Reference: A/8/18/PL for Application for Variation of Condition 2 imposed under A/173/16/PL to read "the development to be carried out in accordance with the following approved plans ADC962/04 REVA, ADC962/13 & ADC962/14 relating to revised position of rooflights on east, north & south elevations. This application affects the Character & Appearance of the Angmering Conservation Area at Land Rear of 1 To 6 The Cottrells Angmering Location: Land Rear of 1 to 6 The Cottrells, Angmering

I write in objection to the above planning application and request that you carry out further detailed investigations before allowing the developer to resubmit any revisions.

A		Layout amended		10.11.17	
Rev		Description		Date	
Job Reference		Client			
New House The Cottrells Angmering, BN16 4AF		AM Homes Ltd			
Drawing Title		Drawing No		Rev	
Ground Floor Plan		ADC962/04		A	
Date	Scale	Dwg Size	Plot Style	Drawn	Checked
24.04.17	1:100	A3	ADC-red	TGS	AD

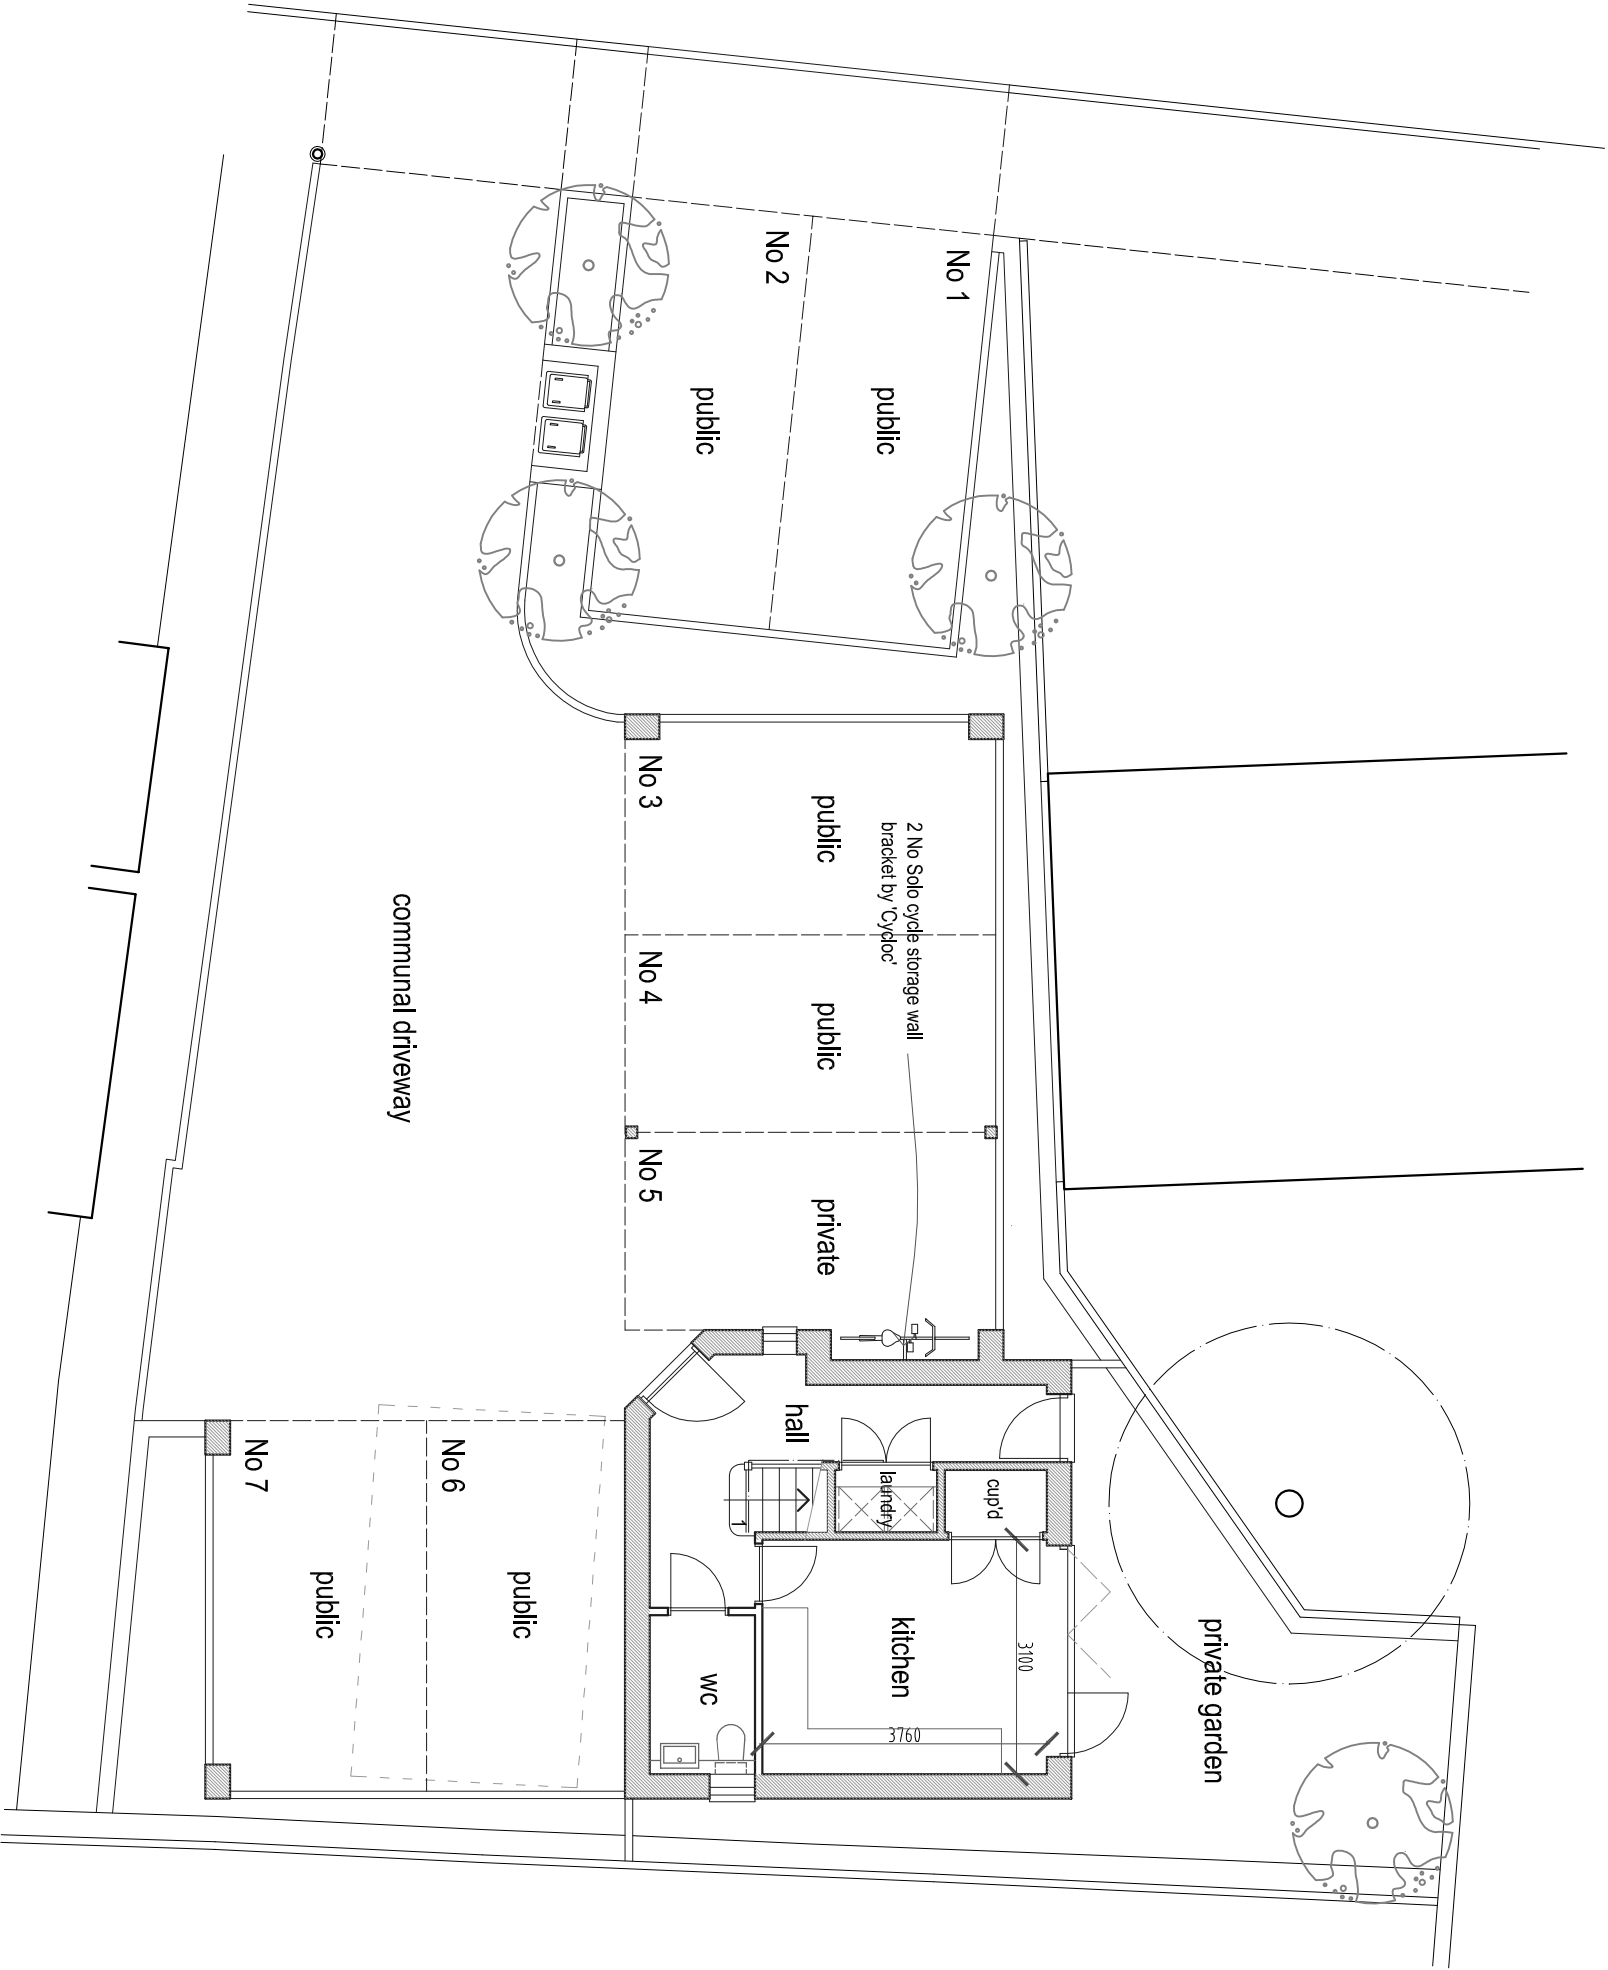
The original approved building was to be sited within the boundaries of the site. However the one that has been built is right on the North and South boundary and the guttering will be over

the adjoining properties (see attached photo). In addition the boundary wall alongside the alleyway at the back of nos 1-5 The Cottrells is over and on this alleyway.

I request that this wall is be removed and placed within the site boundary.

On the plans this is shown as a 2 bedroom property with a downstairs kitchen. The developers submitted plans for a 3rd bedroom downstairs and the kitchen up stairs but this was refused. However the builders seem determined to over ride this and have put the fittings for the kitchen upstairs. A 3 bedroom property would mean that it is highly likely that the residents would have at least 2 cars. The parking in The Cottrells is already oversubscribed and this would create an even greater problem.

I want a restriction put on the property so that the builders cannot change the layout to 3 bedrooms after this planning process has been completed.

Rev	Description	Date
Job Reference New House The Cottrells Angmering, BN16 4AF		
Client AM Homes Ltd		
Drawing Title First Floor Plan & Roof Plan		Drawing No ADC962/13
Date 16.01.18	Scale 1:100	Dwg Size A3
		Plot Style ADgrey.spl
		Drawn AD
		Checked AD

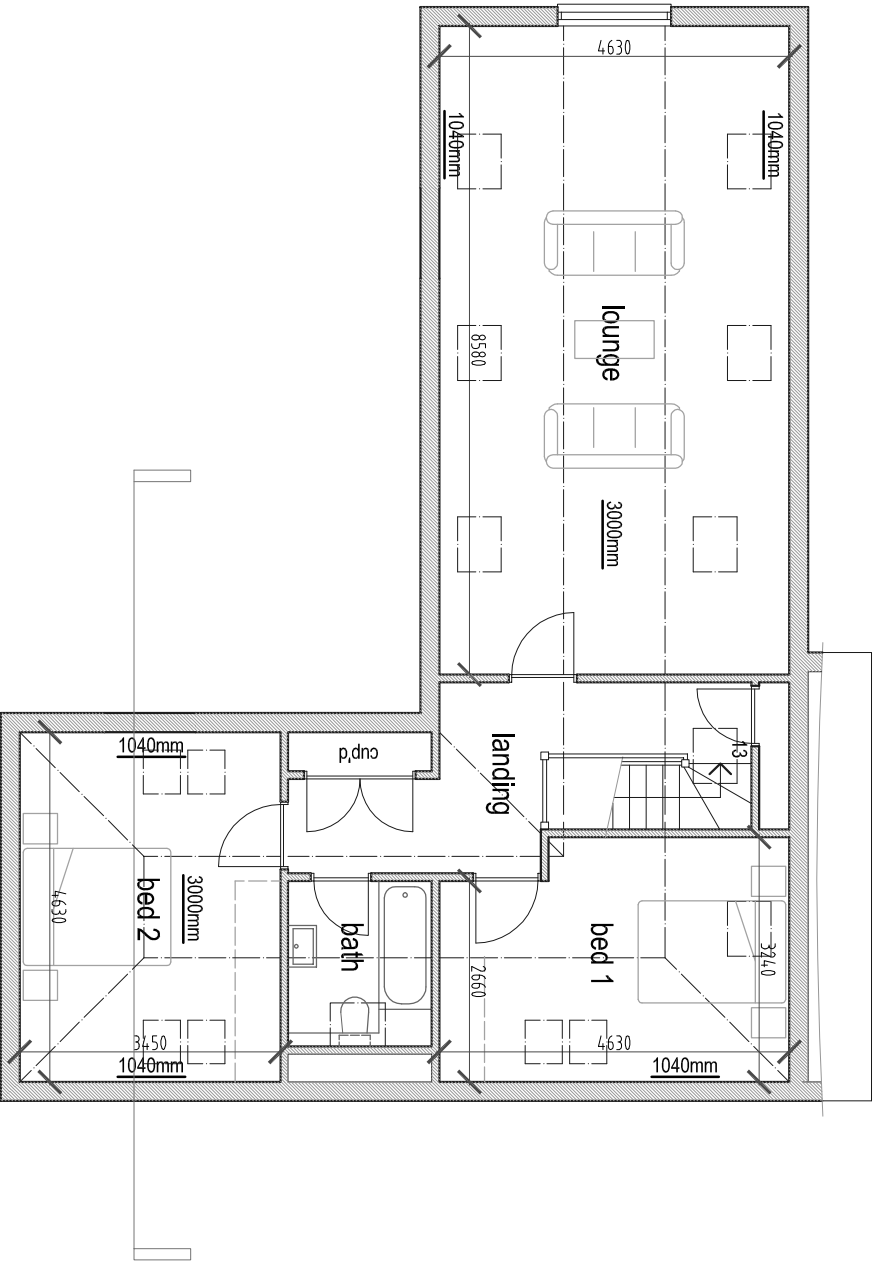
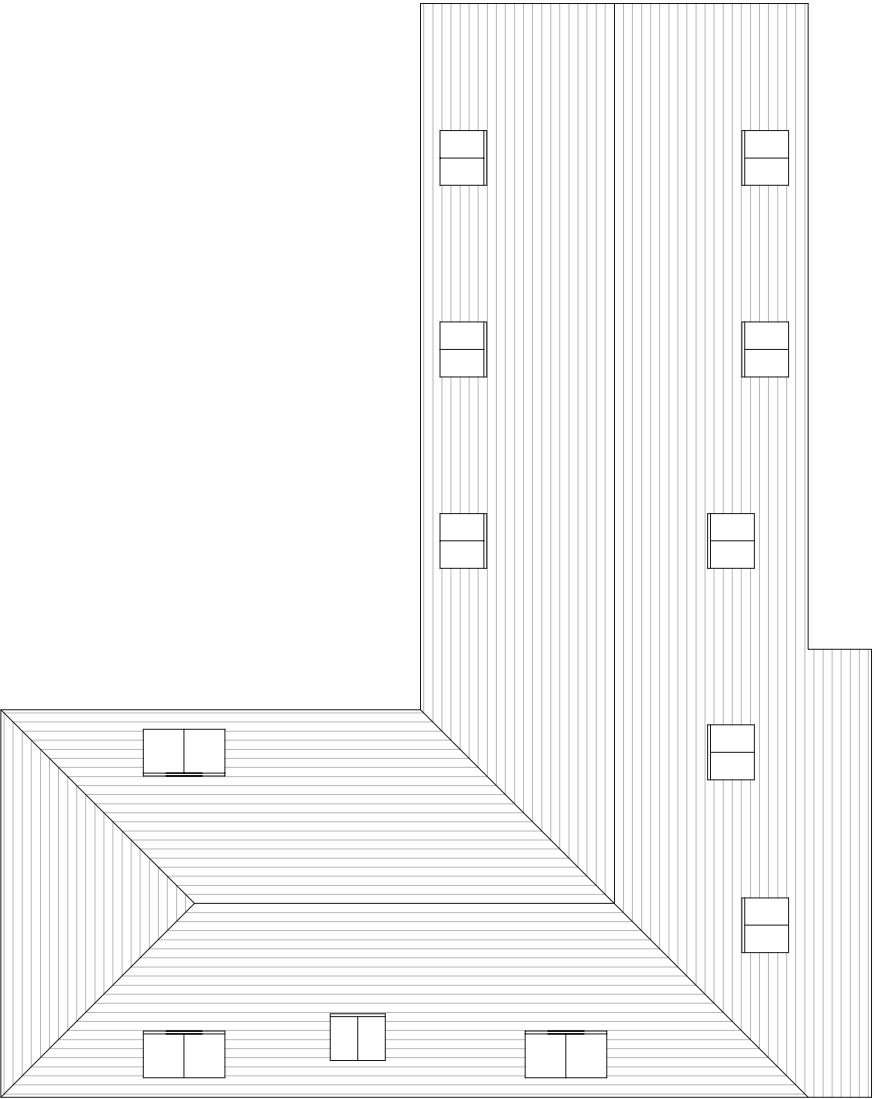
The end of the building facing South is currently built, not as a hip end which was approved in the original plans, but as a barn end. If it is left as a barn end, the end of the slope and guttering will go over into the garden of no 5 The Cottrells.

I want the South facing end of the building to be changed to a hip end, as shown on the plan.

On the plans there are not any windows but escape roof lights. This was to ensure the privacy of nos 1-5 The Cottrells whose bedrooms and bathroom windows are currently overlooked by this property (see attached photo taken from my bathroom window). The builders installed

velux windows which are not approved, nor are they at the correct position ie 1.5m from the internal floor to the lower sill.

I want these windows to be replaced with escape roof lights and in the correct place ie 1.5m from the internal floor to lower sill.

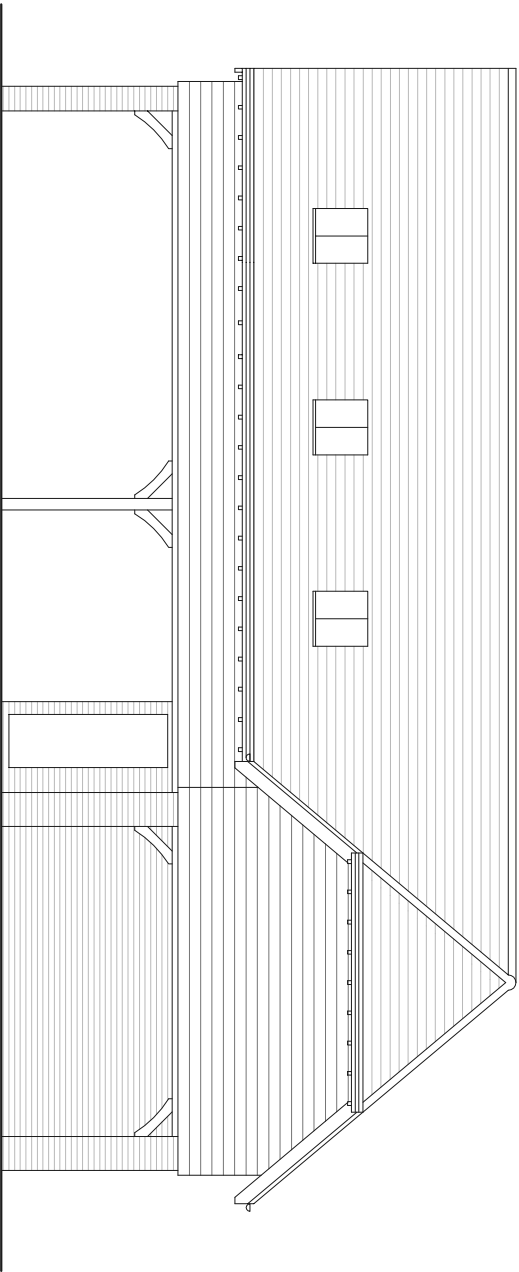
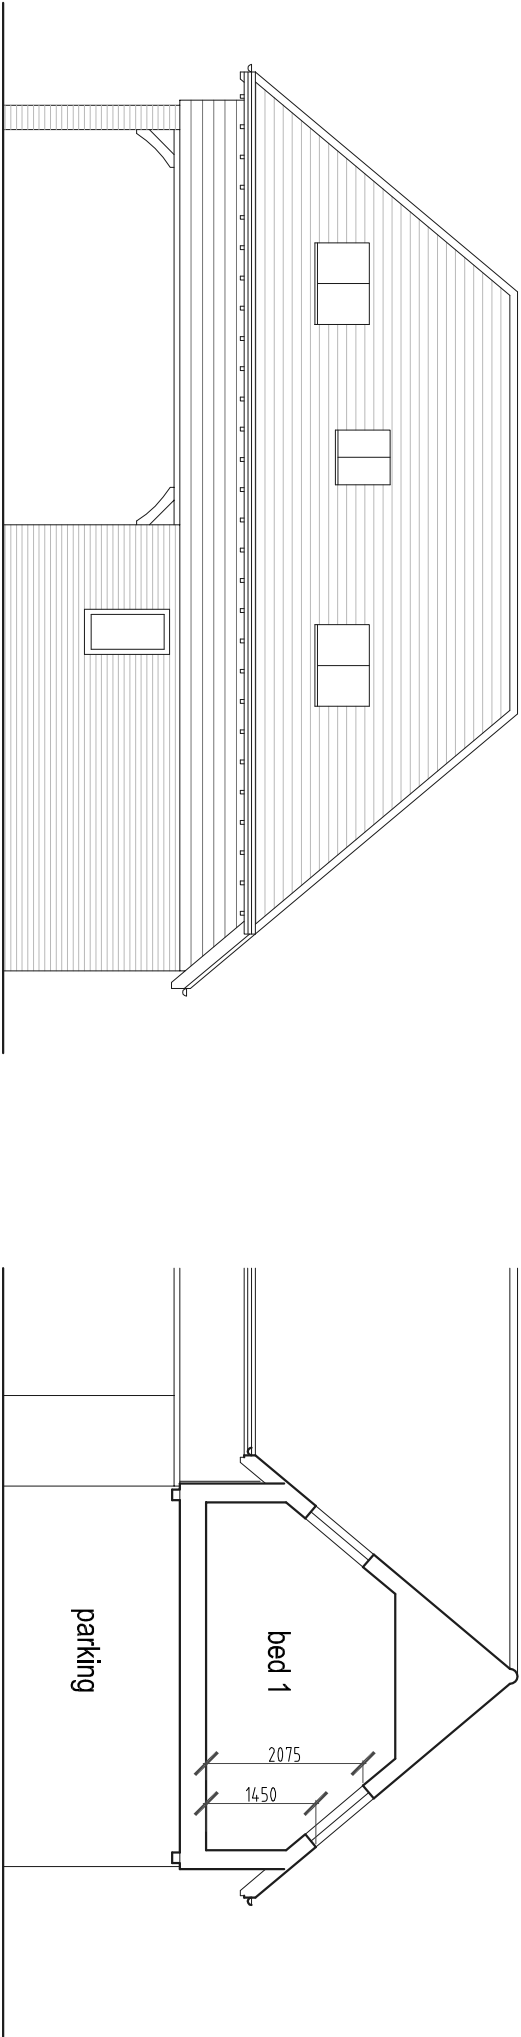
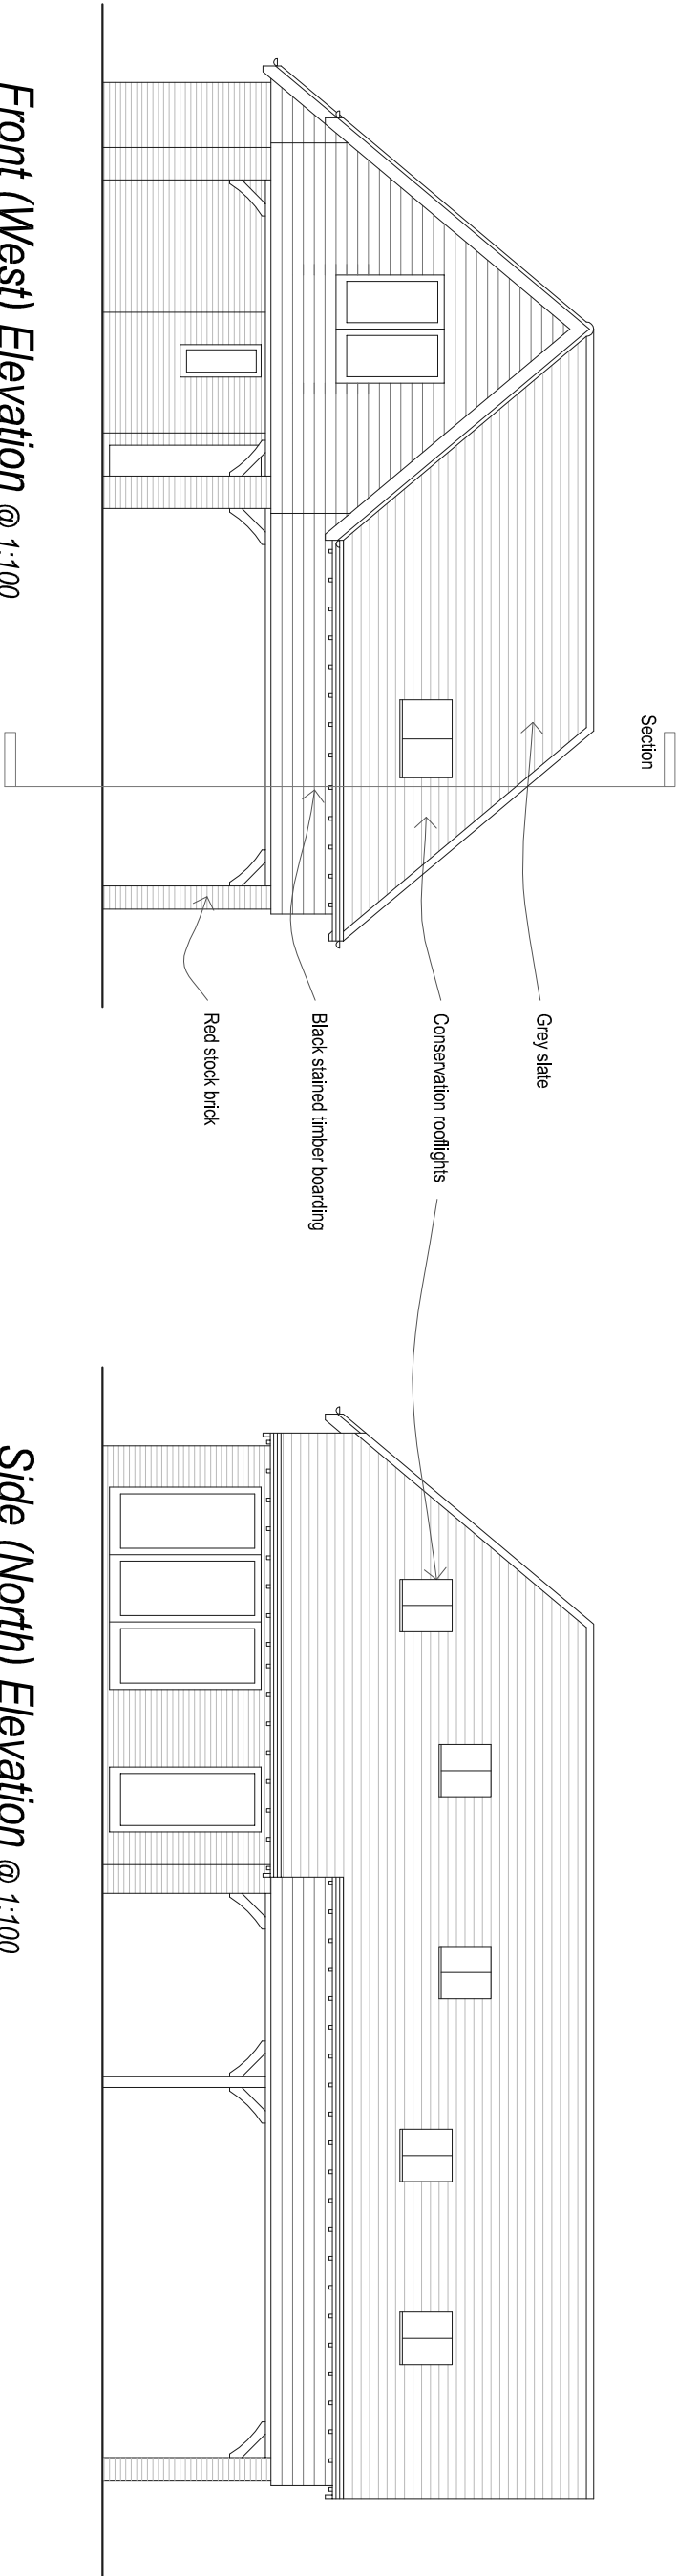
As the building is taking up more of the site than that shown on the original plans (see 1) it must be larger than shown. This 2 bedroom building is larger than the row of 2-3 bedroom houses of 1-5 The Cottrells. I am sure this was not the intention of the planning department. The building is also much higher than the surrounding properties and as such dominates this conservation area.

I ask that measurements including height be taken and action taken to ensure that it complies with the planning permission.

Originally these were to be natural timber supports but the builders have used metal supports which I understand are to be clad with red brick.

I ask that the uprights be covered with natural wood as on the original plan.

The ground level of the building appears to be planned to be higher than the surrounding areas as the drain covers etc are currently above ground level. This would have an impact on drainage to the alleyway along the back of nos 1-5 The Cottrells and the gardens.

I want assurance that the ground level of the site will be the same as the surrounding areas.
